From: The Standard P [REDACTED]
Sent: 14 October 2019 09:07
To: Zac Denton <Zac.Denton@arun.gov.uk>
Subject: Re: EP/50/19/PL - 23 Sea Road

- The information we require relates to condition 5 on the decision notice, which asks for the details of any plant (including ventilation, refrigeration and air conditioning?) and/or ducting system to be used and the method of control of noise and vibration to be submitted and approved by the council. We have received details of the type of plant and ducting but not the second part, which is how any noise and/or vibration will be controlled so as not to cause disturbance to the nearest noise sensitive receptor e.g. a neighbour's window or garden. In order for this information to be provided, we recommended a BS4142 assessment to be undertaken which is usually done by a competent acoustic consultant. To date we have not received this information so at this time are unable to recommend discharge of this condition. I also note that discharge of this condition has not been applied for.

From: The Standard P [REDACTED]
Sent: 30 September 2019 09:26
To: Zac Denton <Zac.Denton@arun.gov.uk>
Cc: Nina Sidhu <Nina.Sidhu@arun.gov.uk>; Kate Giddings <kate.

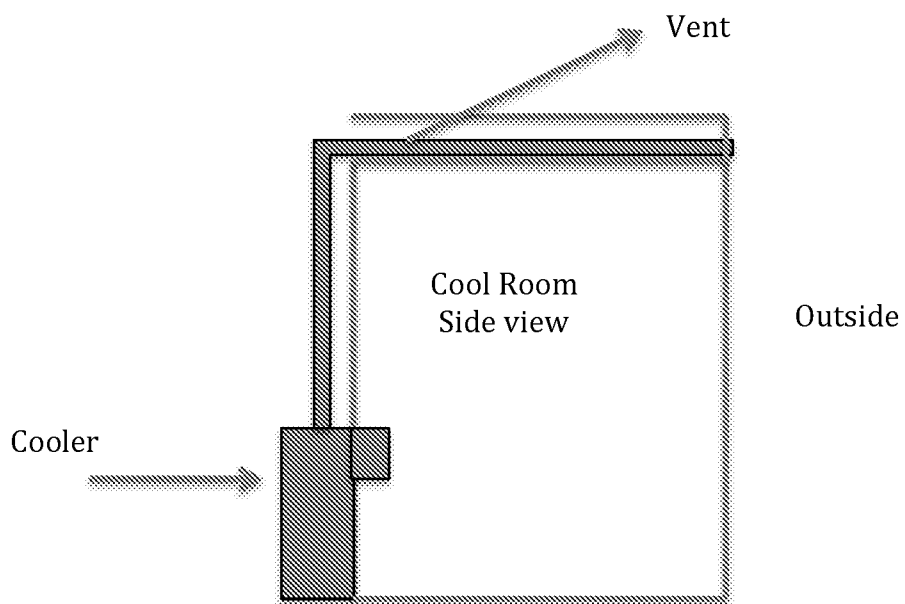
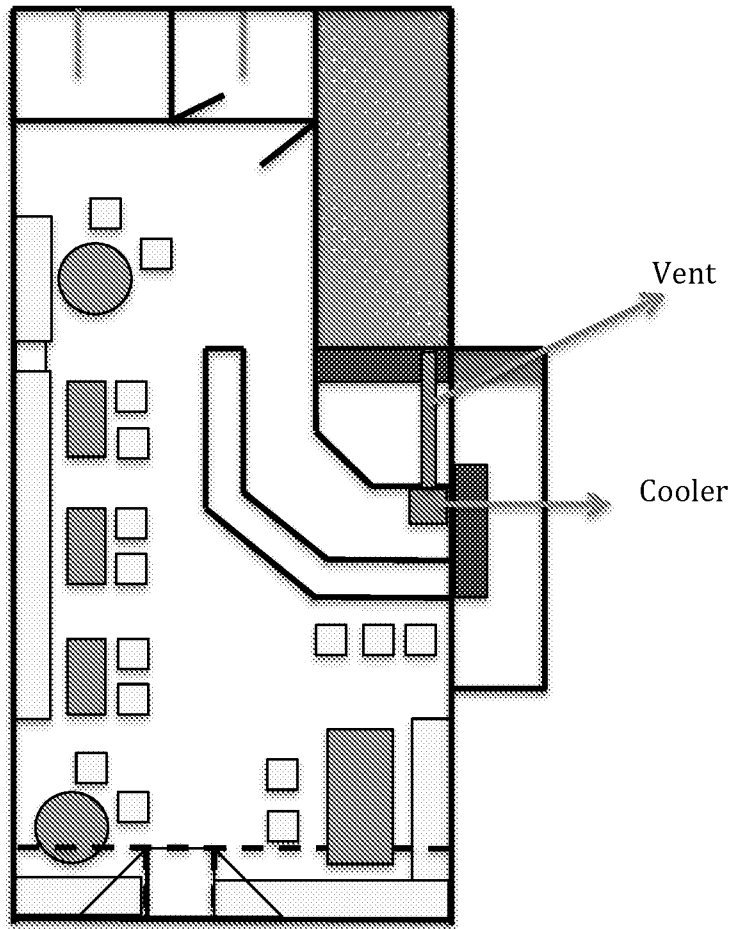
Thank you for the information provided. I regret however, that we still do not have an assessment of the noise the cooler and the associated ducting will make and whether this could impact adversely on the nearest sensitive noise receptor. We appreciate that the plant is not located externally but we do not know the effect of the ducting on the noise e.g. Will the noise be amplified or funneled by the ducting. If we do not receive this information we cannot endorse discharge of the condition. If you were to go ahead with the work as proposed and there was noise nuisance from the cooler outlet, we would need to take action under the Environmental Protection Act 1990. This could involve you in having to undertake costly remedial work to abate the nuisance. This is why we are asking for sufficient information to be provided at this stage.

In order for us to be satisfied that there will be no adverse noise impact we recommend a BS:4142 assessment is carried out by a suitably qualified, independent acoustician.

*what is the distance between the cooler and the termination point of the ducting?

- *what material(s) is/are being used for the ducting?
- *how will vibration from the plant and associated ducting be managed?
- *at what height does the ducting terminate?
- *how far is the termination point from the nearest noise sensitive receptor?
- *when will the cooler/ducting be in operation (for example, when the premises is open/when the temperature rises above a certain threshold/all the time)?

It is recommended that a BS:4142 assessment of the plant and ducting is conducted in order to establish whether the nearest noise sensitive receptor is likely to be adversely affected. It is possible that the ducting can amplify any noise generated so this needs to be thoroughly assessed. I recommend that if the applicant has difficulty in providing the requested information, help is sought from an acoustic consultant. I attach a list of regional acoustic consultants.

The distance from cooler to ducting termination is approx 2.5m.

Plastic ducting held in place with fastening clips and boxed in to top of cool room below new lowered, soundproofed ceiling.

Anti vibration pads for plant and anti vibration clips for ducting.

Ducting terminates at approx 2.4m off FFL

Extraction outlet will be approx 1.5m below the upstairs window, However, there will be no plant on the external or internal wall, as it will only be a vent as the cooler unit will blow the air through the ducting directly.

The cooling unit will only operate when the cooling room drops to a certain temperature.
This will be greatly reduced at hrs we are closed due to all doors being closed to the cool room.
